**Design Heritage and Access Statement for
Overcoombe, France Lynch.**

**Prepared by Coombes Everitt Architects Ltd
on behalf of Mr + Mrs Farr**

October 2023

Drawing title: **Proposed Elevations**

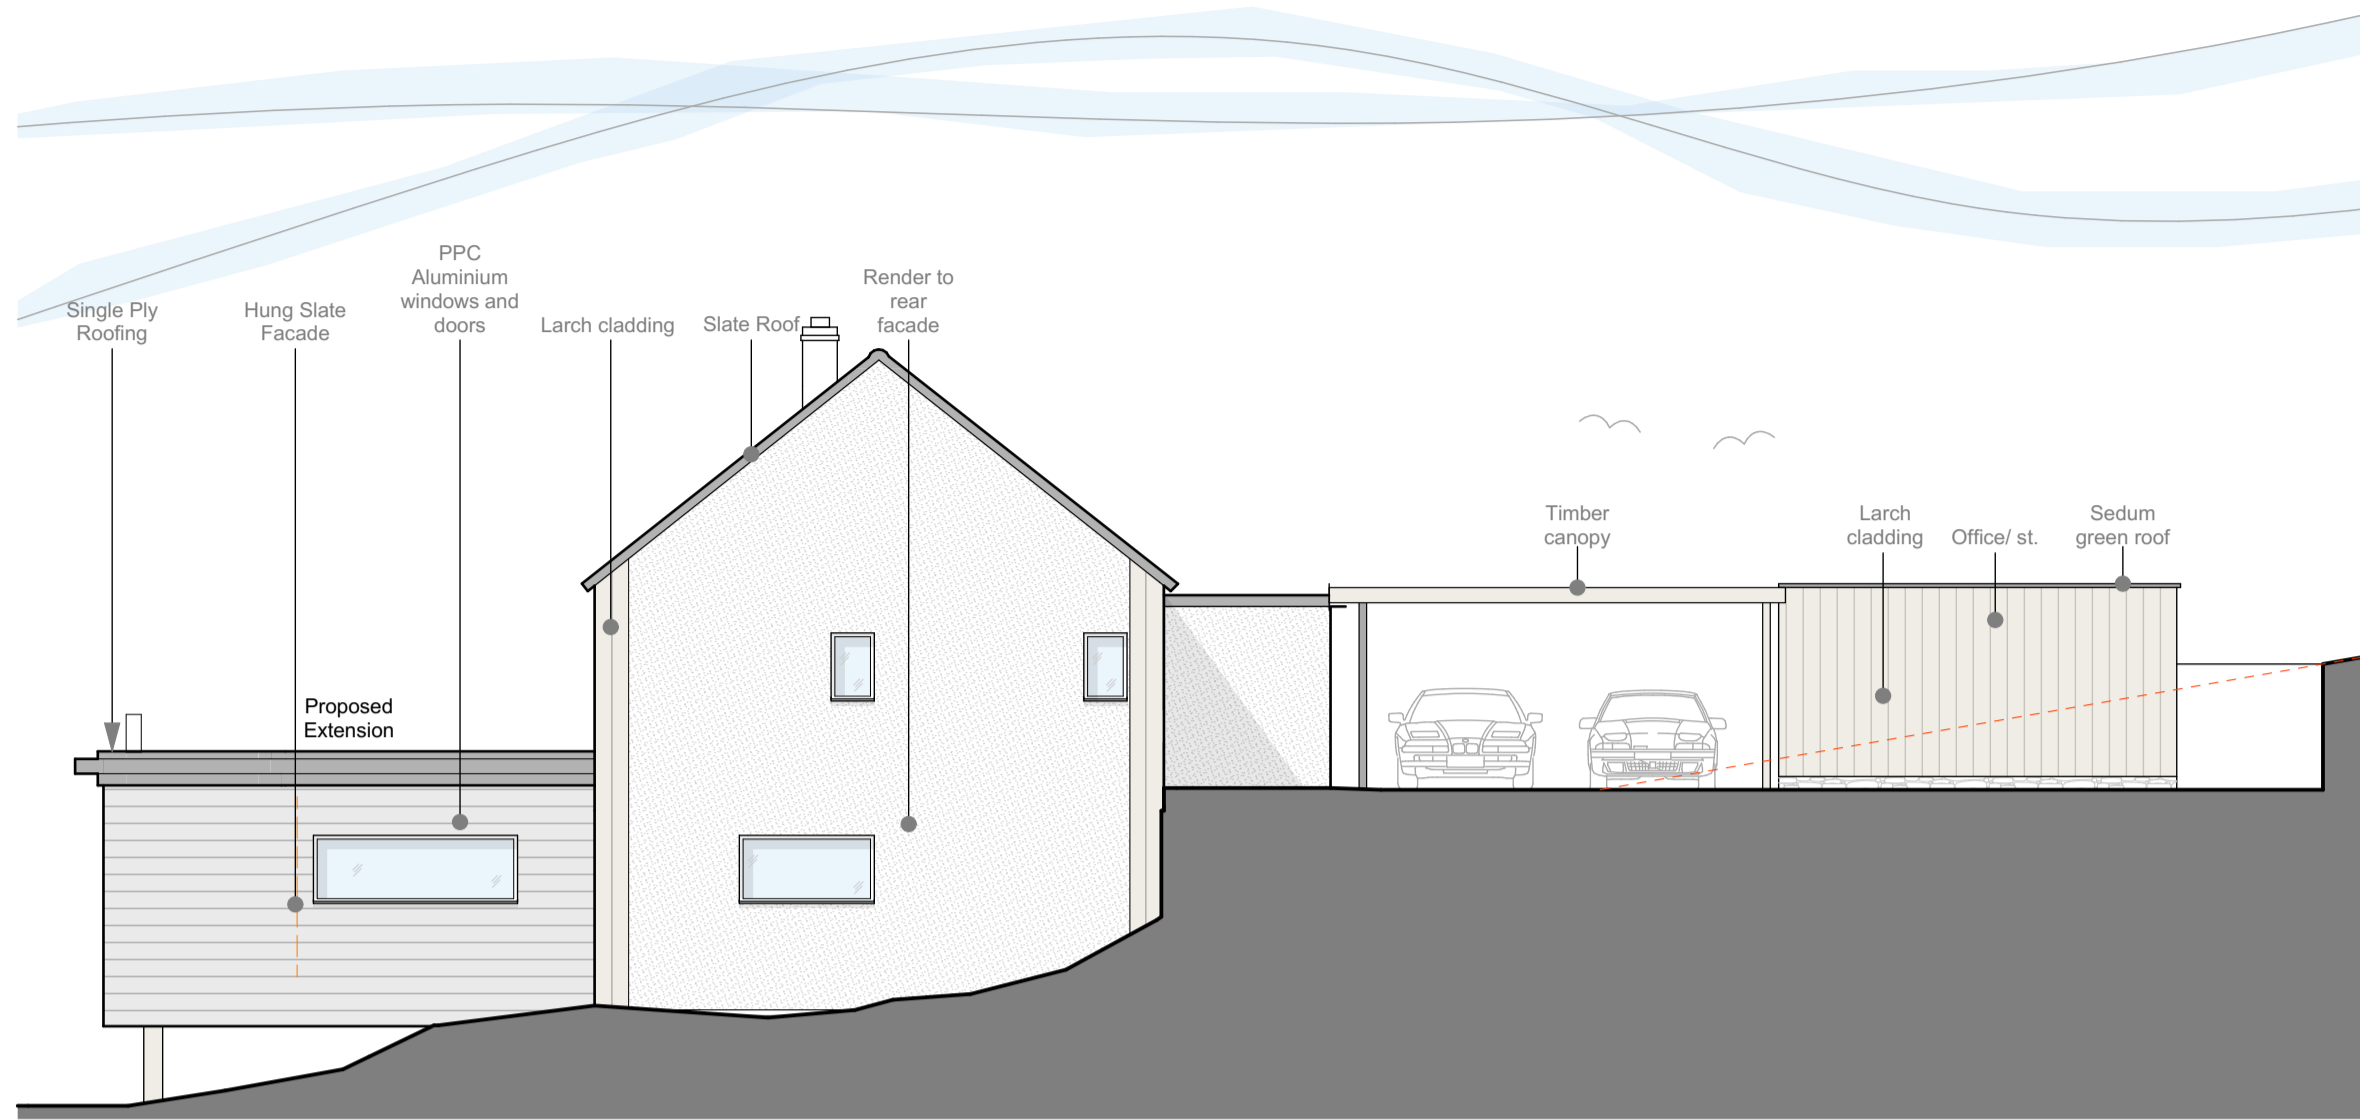
- *The roof lights are consistent in size to the rear elevation and reducing the size of the front facing roof light to match the rear would improve the design.*

- *Officers are not opposed to a single storey flat roof extension but would recommend that the depth of the extension is stepped in by a minimum of 1m so that the addition is more proportionate to the host property.*

- *Officers are not convinced that the proposed bay window fits in with the appearance of the property that you are seeking to achieve. A box window of a more sleeker design would be considered more favourable.*

We have reduced the number of roof lights by omitting the rooflight to the road facing elevation. The rear facing rooflights are now a consistent size

The rear extension has been brought in slightly from the north east so that the outline of the original host building can be seen more clearly.

The bay window that was proposed on the south east elevation of the extension has been removed and replaced with a simple picture window. We feel this is a simpler and less fussy details than the initial bay window proposed.
